Our ref: OUT22/19553

Subject: Birriwa Solar Farm (SSD-29508870) – **Environmental Impact Statement (EIS)**

Detailed advice to DPE Planning & Assessment regarding the Birriwa Solar Farm (SSD-29508870)

Project Layout

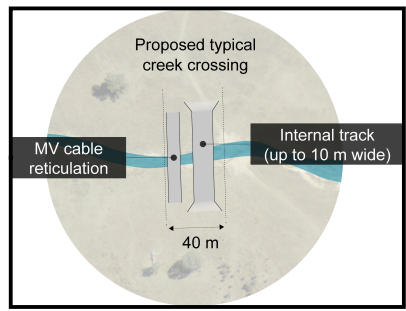
The following recommendations are provided by DPE Water in Attachment A. In particular we require additional information to confirm that the tributary of Whites Creek on Lot 30 DP750755 includes a 30m buffer.

That the proponent ensure a setback has been provided for all third order watercourses within the site in accordance with the Guidelines for Controlled Activities on Waterfront Land.

It is unclear from the information provided if the tributary of Whites Creek on Lot 30 DP750755 also has the 30m buffer provided. This setback should be provided in accordance with the Guidelines for Controlled Activities on Waterfront Land – Riparian Corridors.
